RE: Granite Creek Ranches Boundary Line Adjustment (BL-18-00012)

TO: Community Development Services
FROM: Taylor Gustafson, Environmental/Transportation Planner
DATE: November 9, 2018
SUBJECT: Granite Creek Ranches BL-18-00012

TO: Community Development Services
FROM: Taylor Gustafson, Environmental/Transportation Planner
DATE: December 28, 2018
SUBJECT: Granite Creek BL-18-00012

<b>PRELIMINARY BOUNDARY LINE ADJUSTMENT</b>			
A PIN OF THE E 1/2 OF THE SW 1/4 & A PIN OF THE W 1/2 OF THE SE 1/4, SECTION 3, TOWNSHIP 19 NORTH, RANGE 14 EAST, W.M., WASHINGTON.			
OWN BY	DATE	JOB NO.	
S.W./G.W.	10/2018	01580-1	
CHKD BY	SCALE	SHEET	2 OF 2
M.A.K.C.	N/A

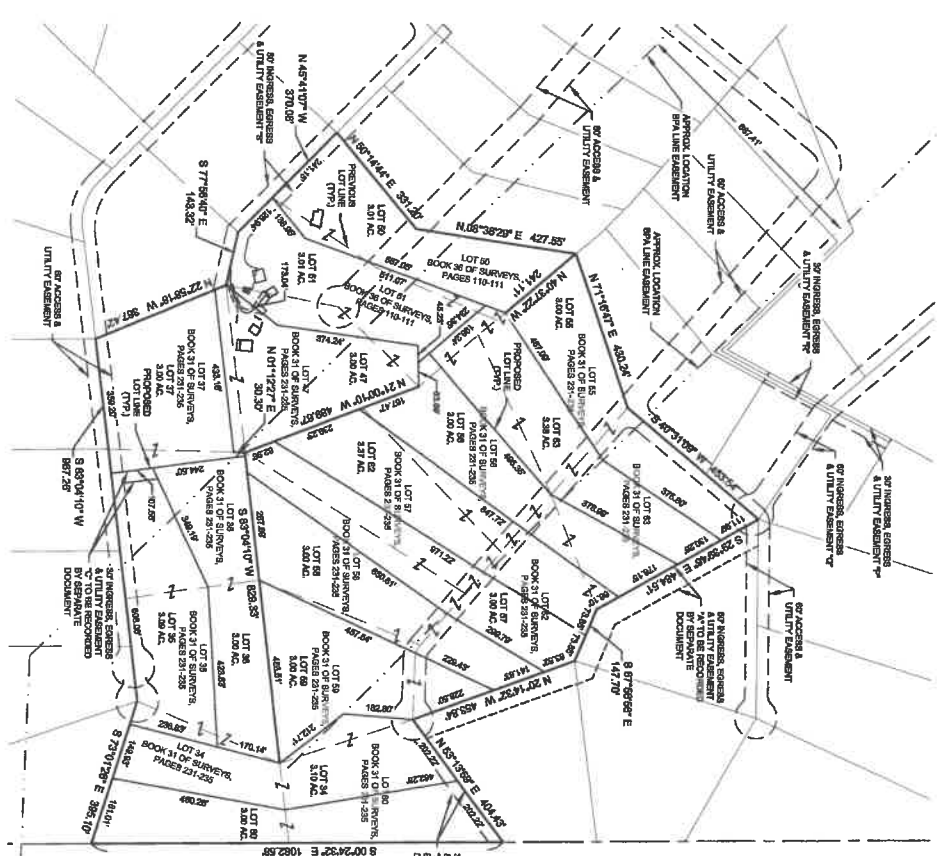
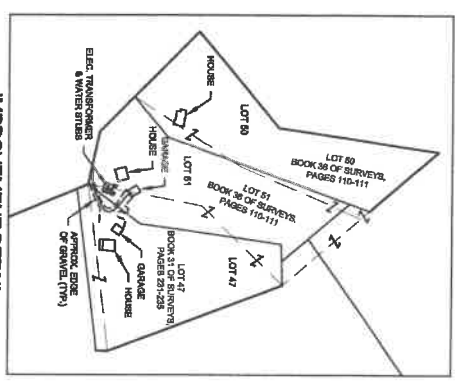
1. Road standards may vary depending on the access location for the new buildable lots 55A, 63A, 56A, 62A, 57A, 58A and 59A of the review draft record of survey dated 12/2018. The applicant shall work with Public Works to establish the access in which these properties will be served from to determine the private road standards that will apply. All private roads must be constructed and certified to meet the current 2015 private road standards prior to final approval.

2. All access roads serving 6 or more lots in total need to be named through the private road naming process prior to final approval.
3. Private road names need to be shown on the face of the survey.

4. All easements are to be labeled with recording numbers.
 - a. Joint use easement between lot 51A and 47A needs to be labeled.
5. Fire Apparatus turn arounds required on all roadways with appropriate turning radius per the International Fire Code Appendix D.

6. The proposed BLA creates additional buildable lots that impact the Forest Service Roadway. An updated Forest Service access agreement approval is required with consideration to the new BLA.

7. All driveways or joint use driveways are required to meet the current International Fire Code Appendix D.

1. BPA towers appear to be located within the 10 foot Utility easement reserved along all property lines. Applicant may need to speak with Community Development Services in regards to this matter.

1. The West boundary of Lot 50A has lines crossing text (331.20') that may become difficult to read after scanning.
2. The West boundary of Lot 55A has lines crossing text (S40-31-09W 453.54') that may become difficult to read after scanning.

3. The South line of Lot 59A is missing a bearing.
4. The area near line "L19" is crowded and difficult to determine.
5. The Surveyors Certificate is missing.

6. All existing easements should include references to the record documents. In the case of the BPA easement, a note stating that the easement as shown is approximate and based upon the following AFN's:.....

7. Ensure that the separate document used to create the access easement for lots 47A and 51A provides a suitable description to delineate the easement, OR add suitable line labels to the face of the map to do the same.

8. There appears to be a double cul-de-sac near the Southeast corner of Lot 35A.
